# CITY OF ALBUQUERQUE

April 27, 2009

**Re: Eagle Rock Commons Bldg B, 5501 Eagle Rock NE,  
(C-18/42A) Approval of Permanent Certificate of Occupancy,  
Engineer's Stamp Dated: 12-26-07  
Engineer's Certification Date: 4-20-09**

GRADING & DRAINAGE PLAN

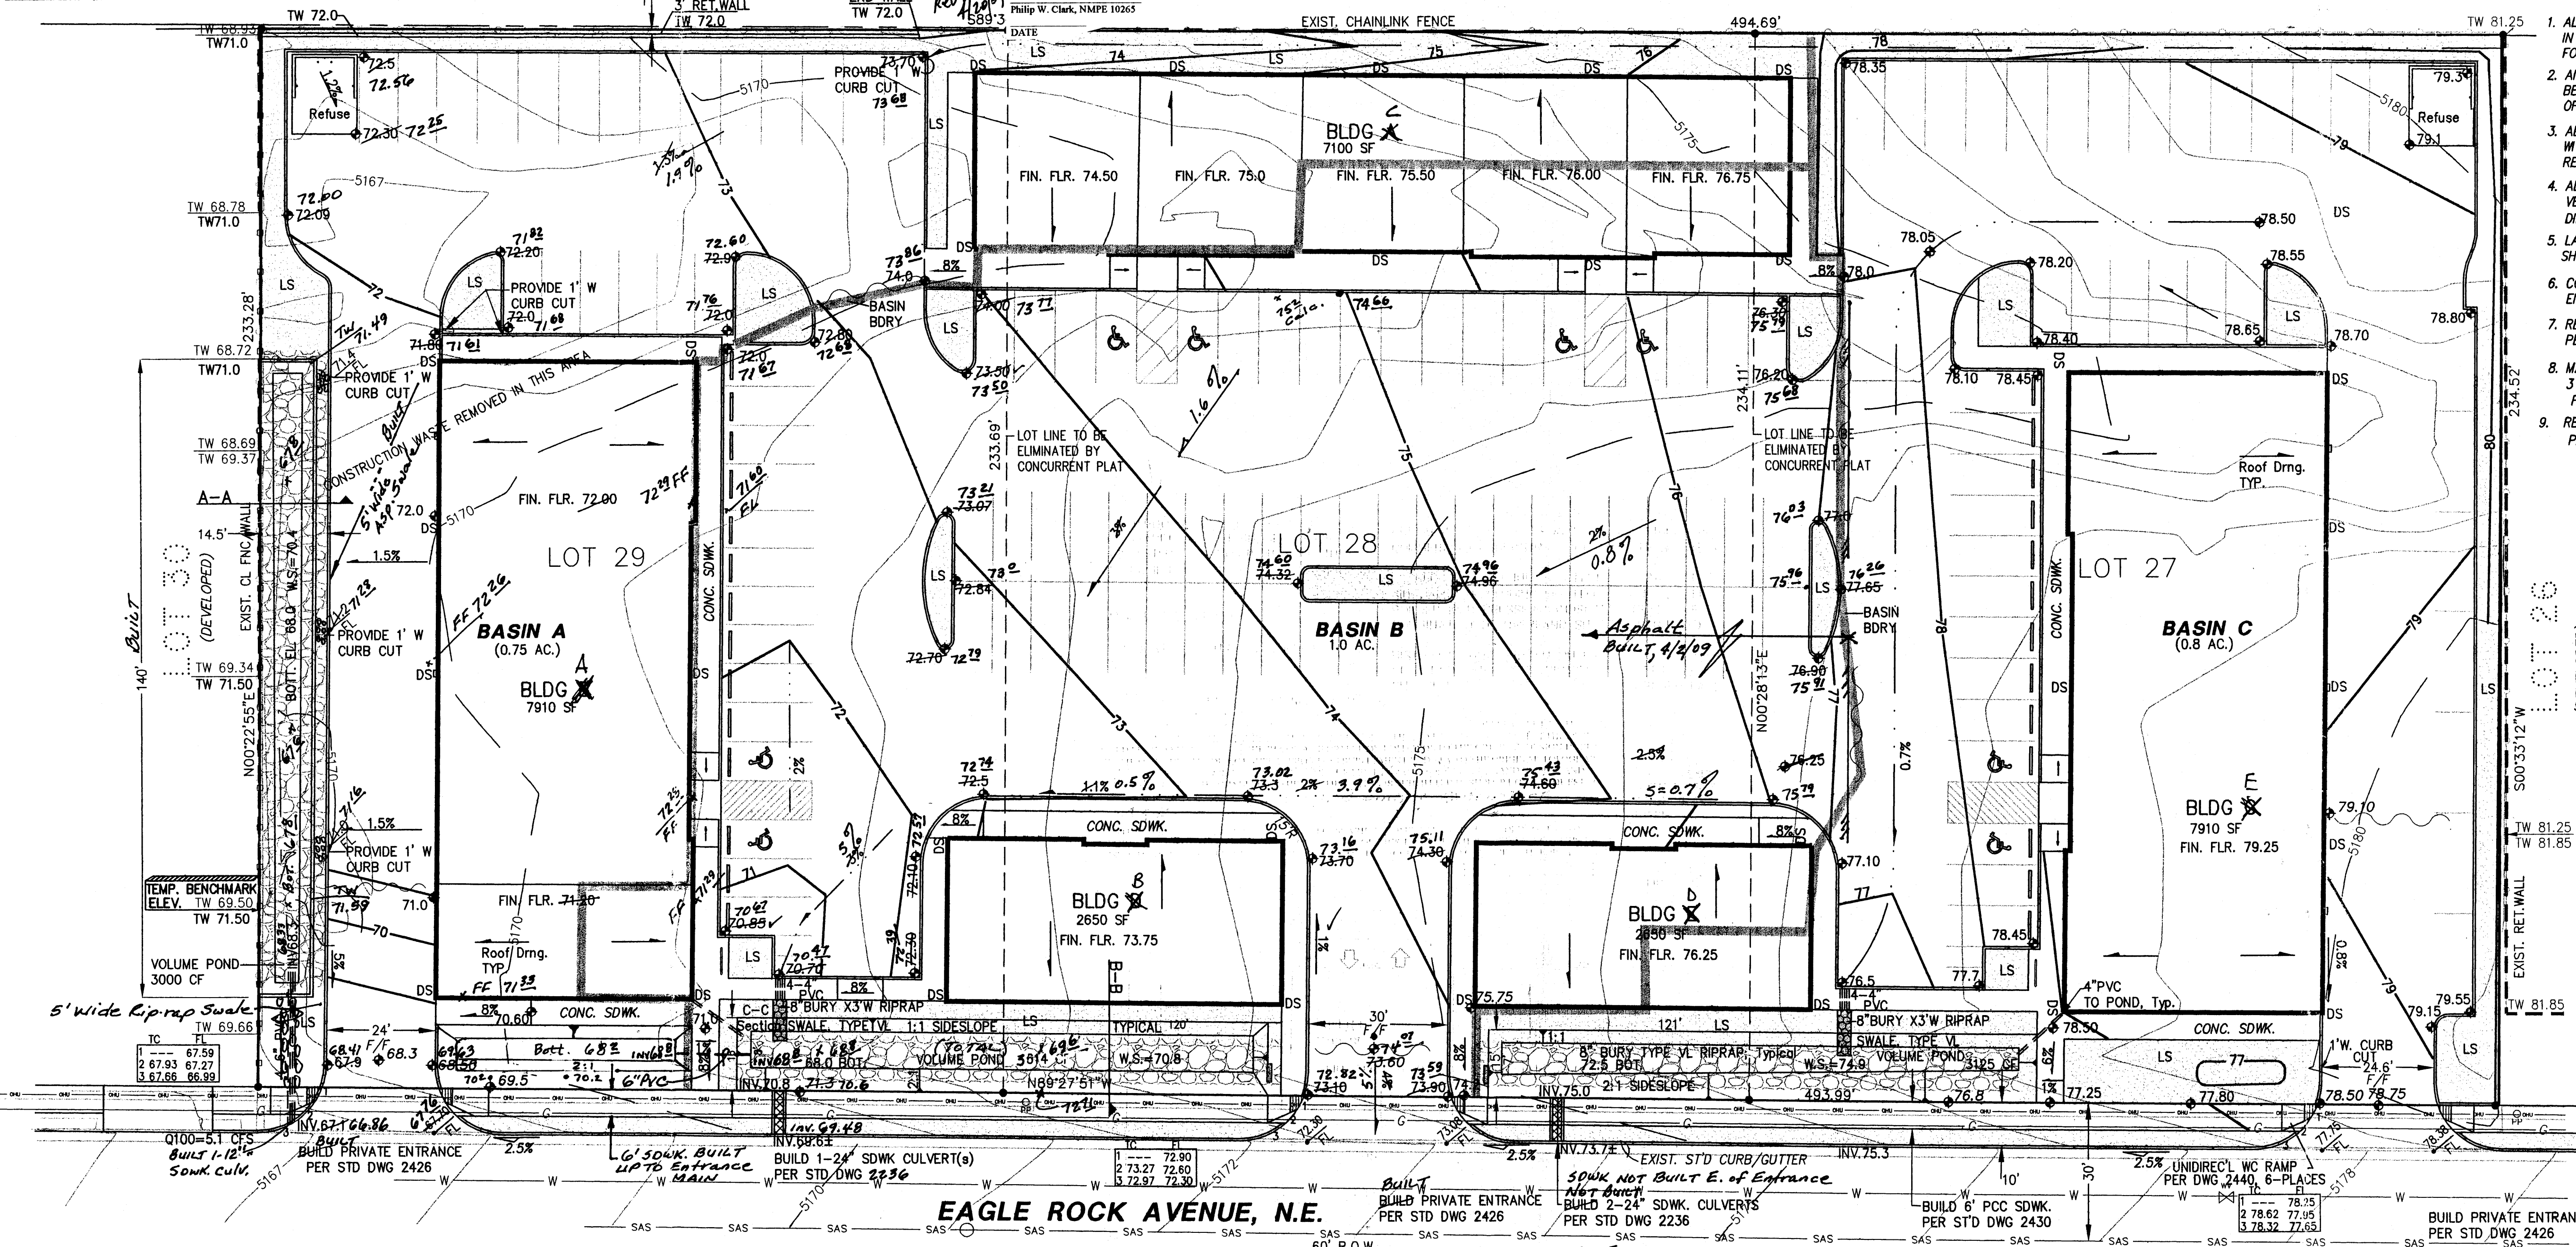
- The handrail around the western most retention pond will need to be constructed. The rock lining must also be completed.
- The pond volume south of Building D will need to be certified. After a site visit the spot elevations on the plan do not reflect the as-built conditions.
